4 November 2015

**State Significant Development Application SSD 6617: Notice of Exhibition
Remediation of part Hickson Road within EPA Declaration Area, Barangaroo**

Figure 1: AM Peak Hour Traffic Flows, July 2013

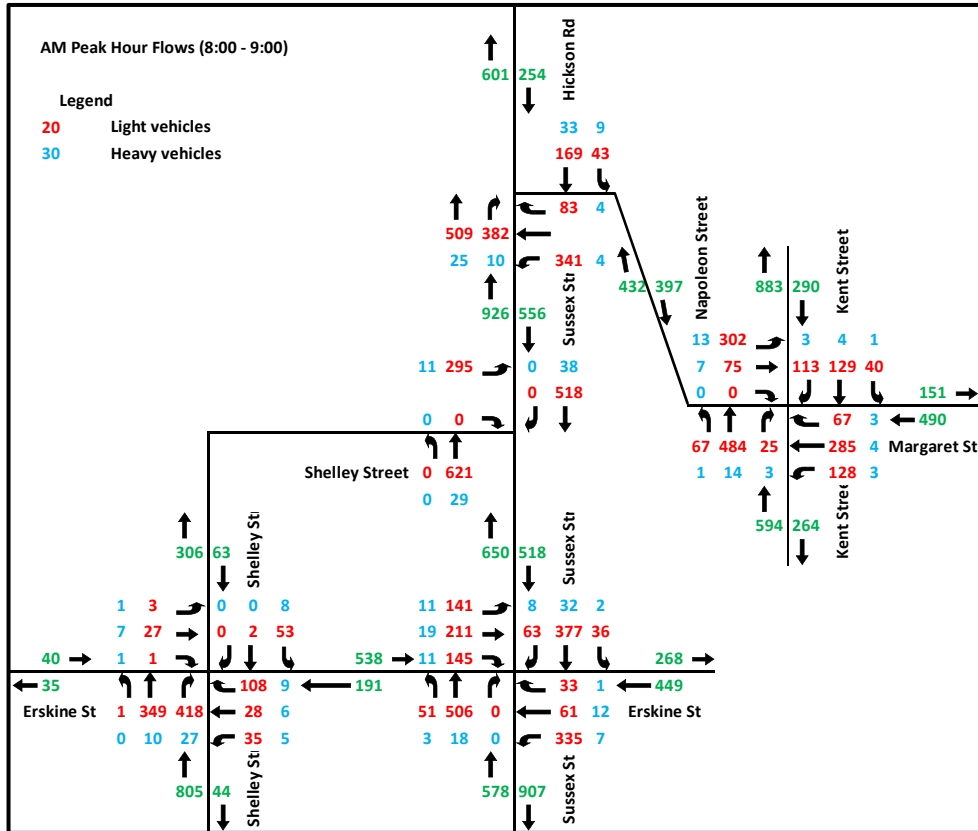
- Port Authority considers that the traffic assessment modelling and intersection analysis should be re-done based on current traffic numbers, not relying on traffic counts done in July 2013, which does not adequately reflect present-day conditions, current construction traffic impacts and traffic changes in the CBD, due in significant part to the light rail construction on George Street.

Figure 9 Truck Access Route – Hickson Road Remediation (Western Side)

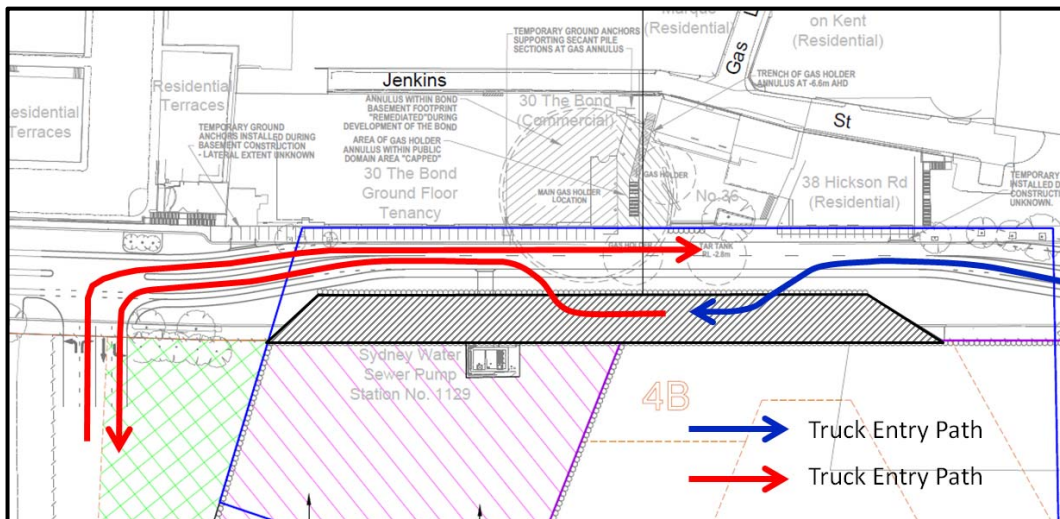
1. 24 hour access must be maintained on Hickson Road with any proposed lane diversions having a suitable geometry to accommodate unimpeded two-way traffic for fully-laden 19m articulated trucks. This is not addressed in the application and particularly in section 6.1.3 of Appendix S.
2. Port Authority requires a minimum of three months notification of road changes and closures in relation to the proposal so that we can inform the relevant OPT
